WEST SUSSEX COUNTY COUNCIL CONSULTATION

TO:	Arun District Council FAO: Anita Gardner
FROM:	Highways, WSCC
DATE:	29/10/2018
LOCATION:	Land at, Asda Superstore, Littlehampton Road, Ferring, Worthing, BN12 6PN
SUBJECT:	FG/149/18/DOC Application for approval of details reserved by condition imposed on planning ref FG/105/18/PL relating to conditions 4 (Surface water drainage), 6 (Risk of contamination), 10 (Construction management plan) & 13 (Surface water drainage)
DATE OF SITE VISIT:	n/a
RECOMMENDATION:	☒ Advice ☐ Objection ☐ Modification ☐ No Objection ☒ More Information ☐ Refusal
S106 CONTRIBUTION TOTAL:	n/a

### Site set up plan

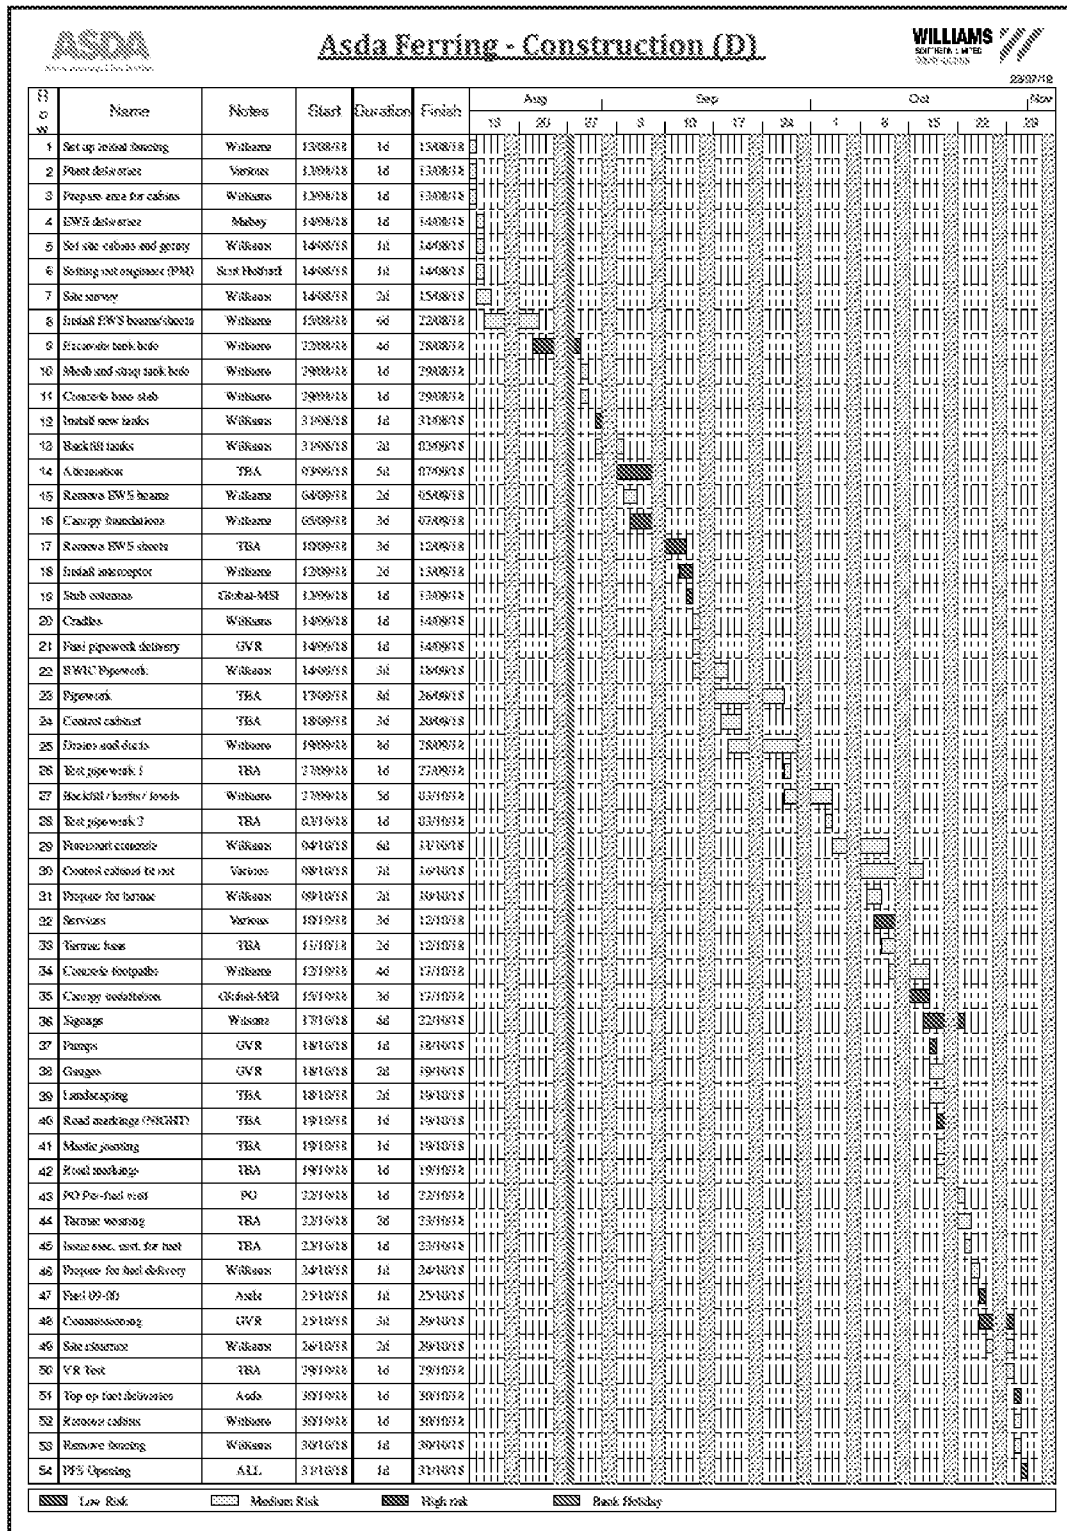
The applicant has submitted a Construction Methods Statement to fulfil the requirements of this condition. In principle the details within the plan would be considered acceptable to the Local Highways Authority. However the 'Site Set Up Plan' appendices in the document is at a poor resolution the details cannot be checked. I would ask a more legible version of this plan is made available before being fully satisfied with the plans and details provided.
